From: Rod Brown [REDACTED]
Sent: 21 April 2021 19:03
To: Anita Gardner <Anita.Gardner@arun.gov.uk>
Subject: LU/50/21/PL : Proposal to place 20 Beach Huts at Sea Road Littlehampton.

I am writing to place an objection against the proposal by Arun District Council to place 20 additional beach huts south of the promenade to the East of the East beach Cafe at Norfolk Road and Sea Road, Littlehampton.

Block Plan (East Part). Scale 1:500 at A3
Arun District Council Beach Hut Application
Red rectangles represent proposed positions
February 2021

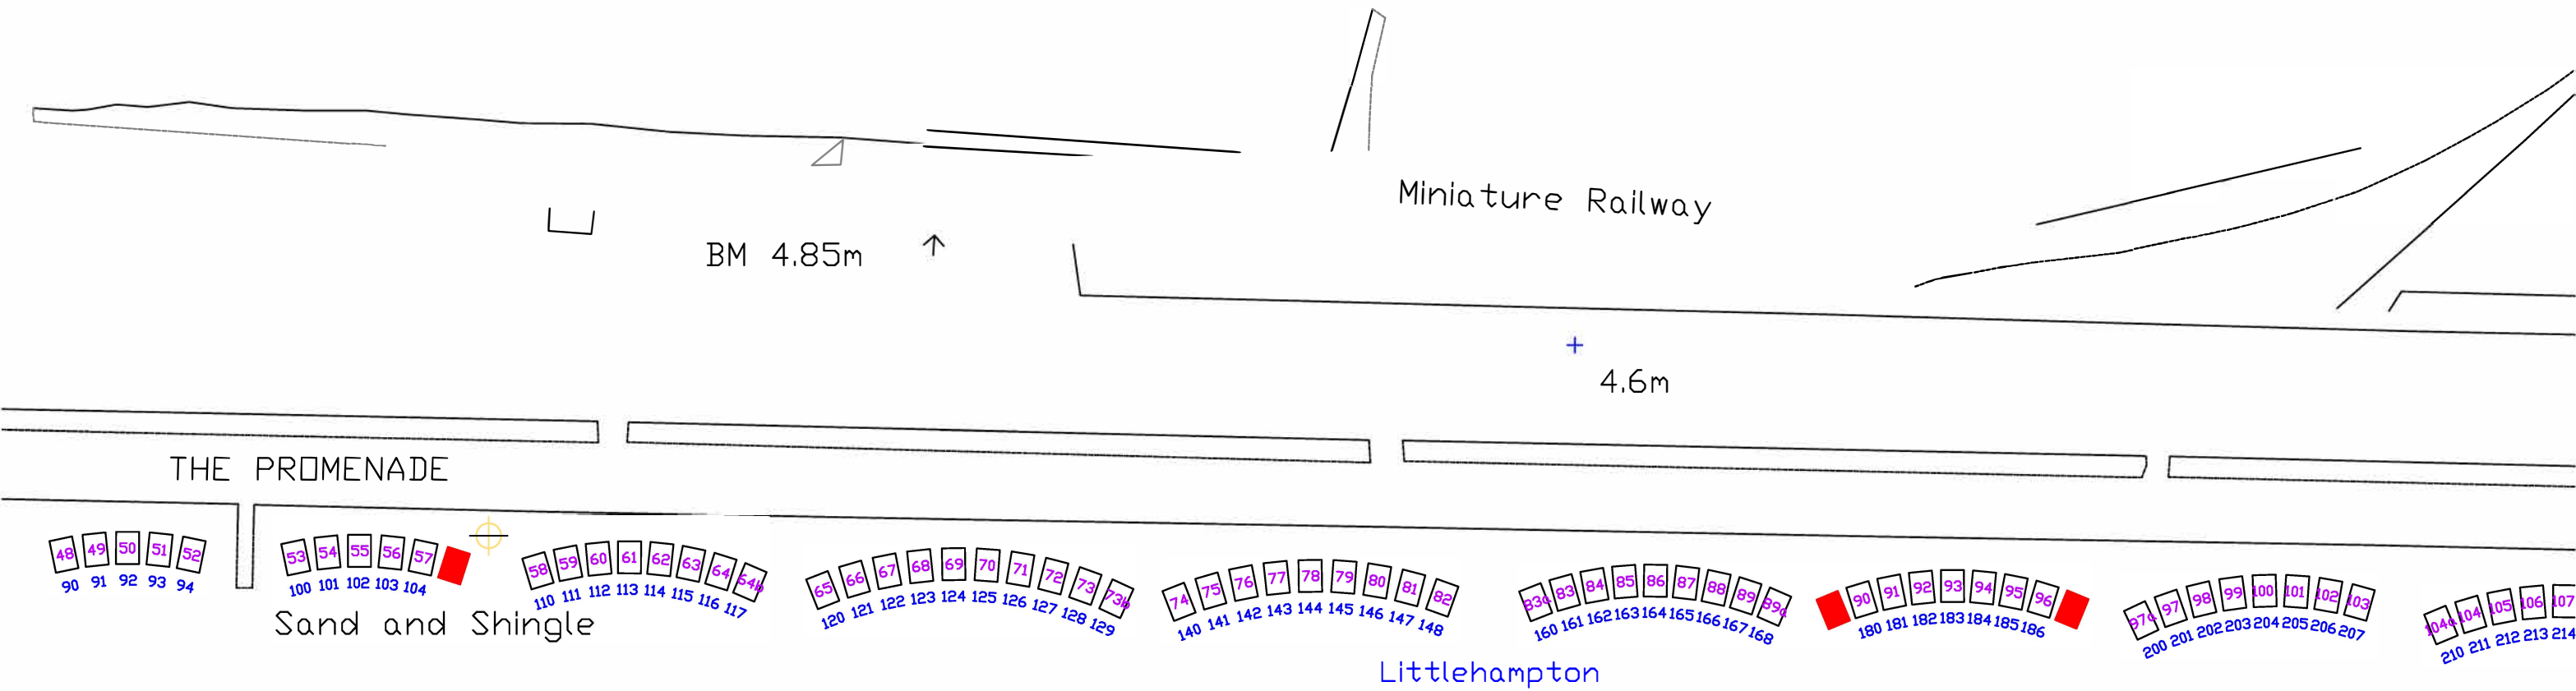
I have no doubt whatever that the proposed increase in the number and density of beach huts eastwards from the East Beach Cafe will have a highly destructive effect on both these characteristics, and in practice the damage will be irreversible for several generations to come, considering that there have been beach huts along Sea Road from a point further East for around a century, and the number and extent has increased over that time.

Arun District Council Beach Hut Application
Block Plan (West Part). Scale 1:500 @ A3
Red Rectangles Represent Proposed Positions

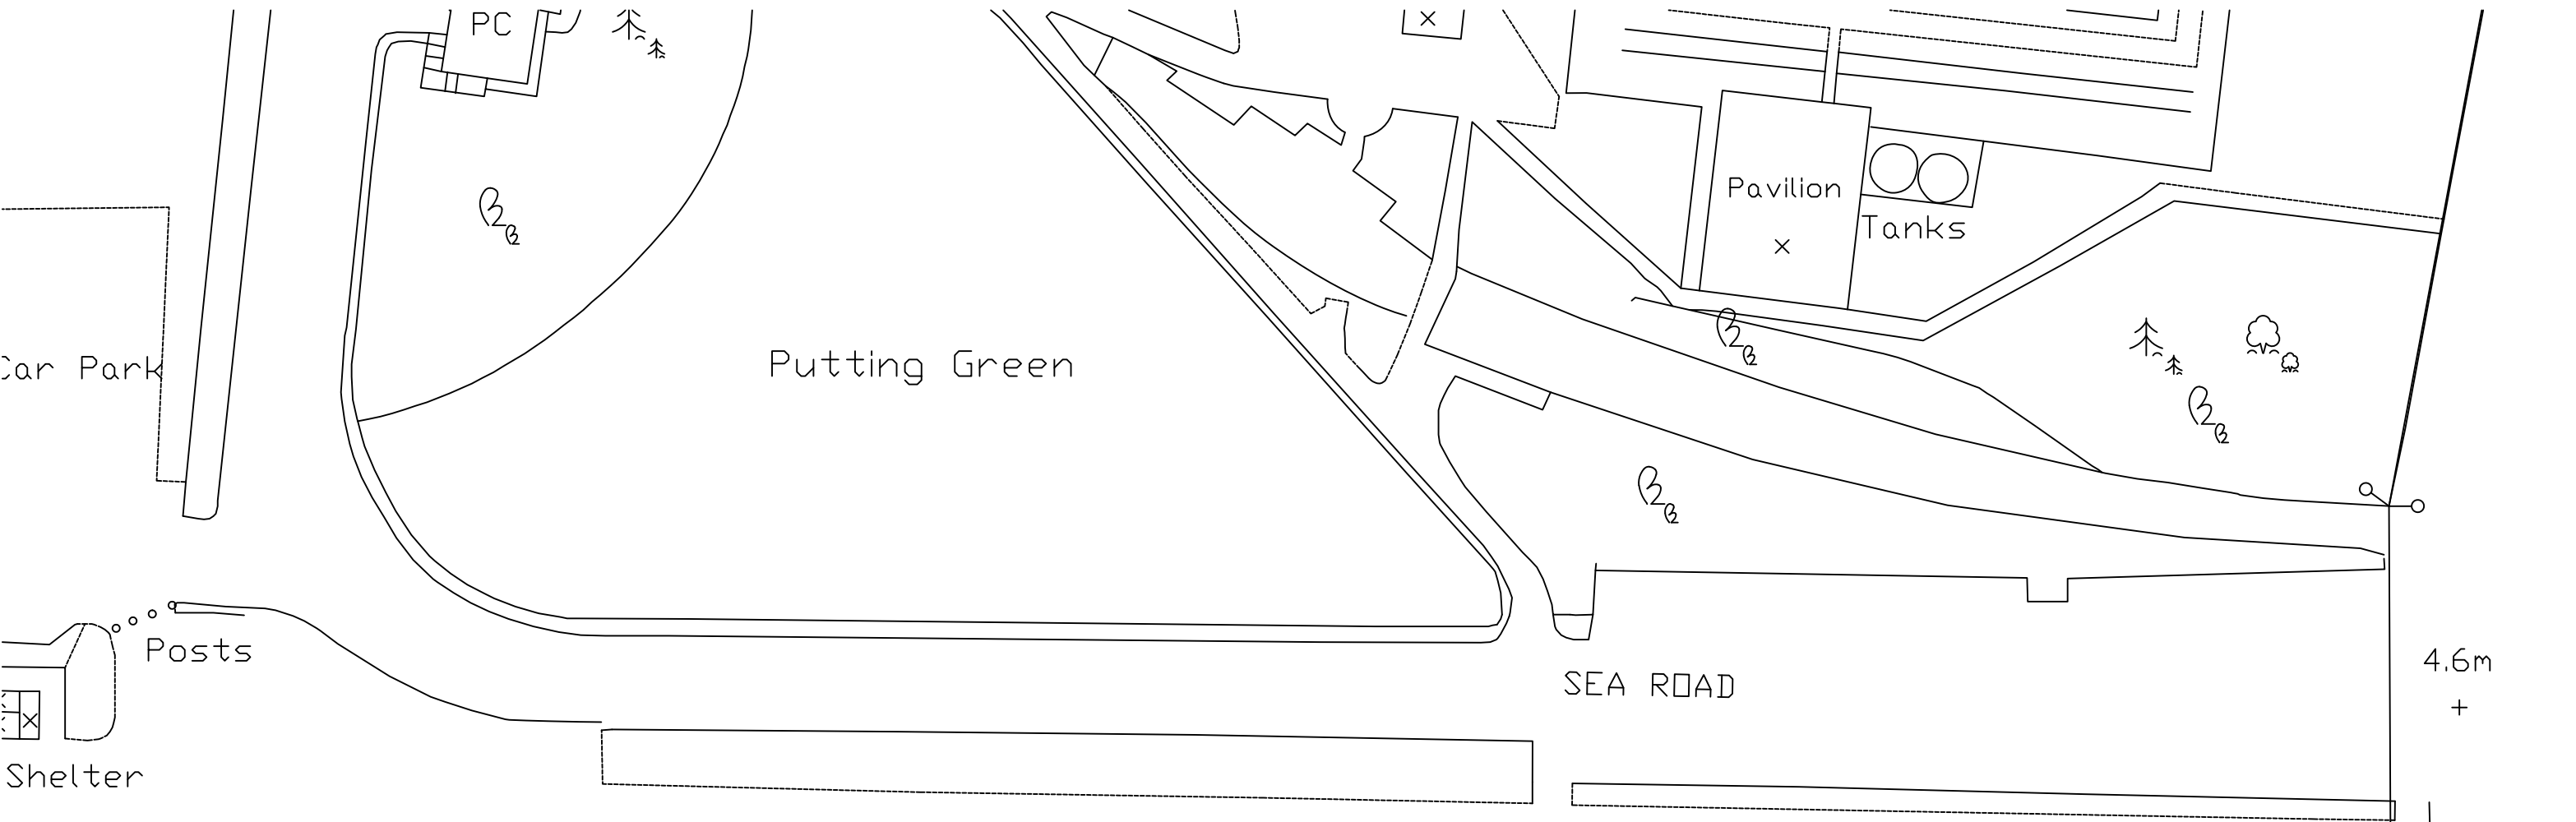
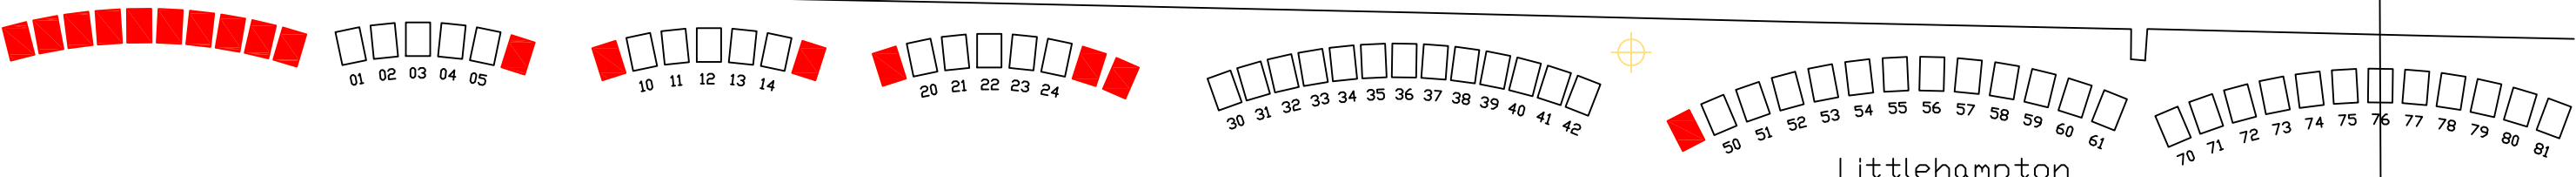
But the proposed additional group of ten huts at the west end of the row is an even bigger act of destruction, because it will utterly ruin the only view of the sea, with horizon and sky meeting, in the entire town from Street Level. It is beyond belief that the unique value of this place isn't recognised by either Littlehampton Town Council comments or in the Planning Officer's Report that were on the Arun DC Website until 21st April.
